**Consultation Response from KC,
Lead Local Flood Authority**

**2023/91405 Part of former St Luke's Hospital site, Blackmoorfoot Road, Crosland Moor,
Huddersfield, HD4 5RA**

**Erection of foodstore (class E) with associated access, parking, servicing area and
landscaping**

Date Responded: 9th June 2023

Drainage Strategy - Scale (1:250)

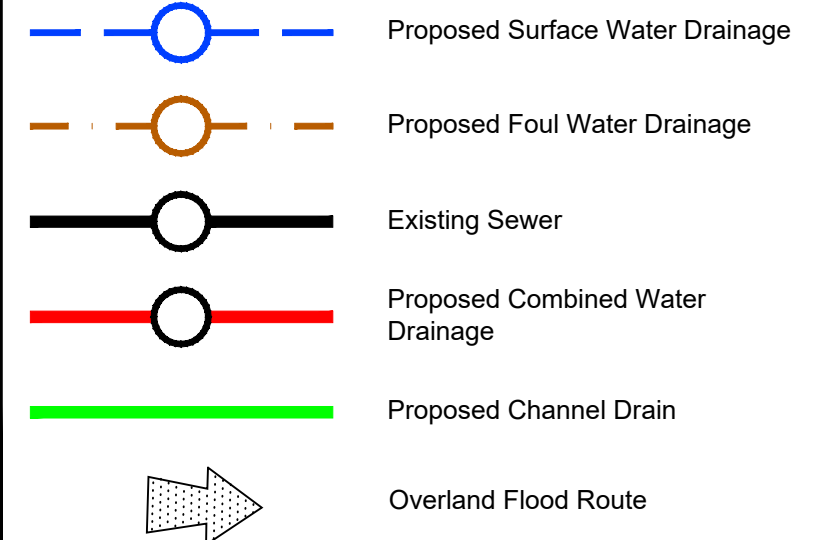
The drainage strategy drawing shows a discharge rate of 2.5l/s with a flow control orifice size of 65mm which is below the allowable minimum and would be prone to blockages.

It is only fair to examine the master plan for the residential development under discharge of condition application 2019/93291 that showed a discharge from the residential part A of 148.3l/s and an allowance for the commercial area that is now submitted under this application, 2023/91405, of 41.9l/s. Drawing Ref E18/7232/002A, Haigh Huddleston, Proposed Drainage Strategy Plan.

As this application was in 2020 we believe the discharge agreement would still stand and the flow restriction and tank design can be altered accordingly.
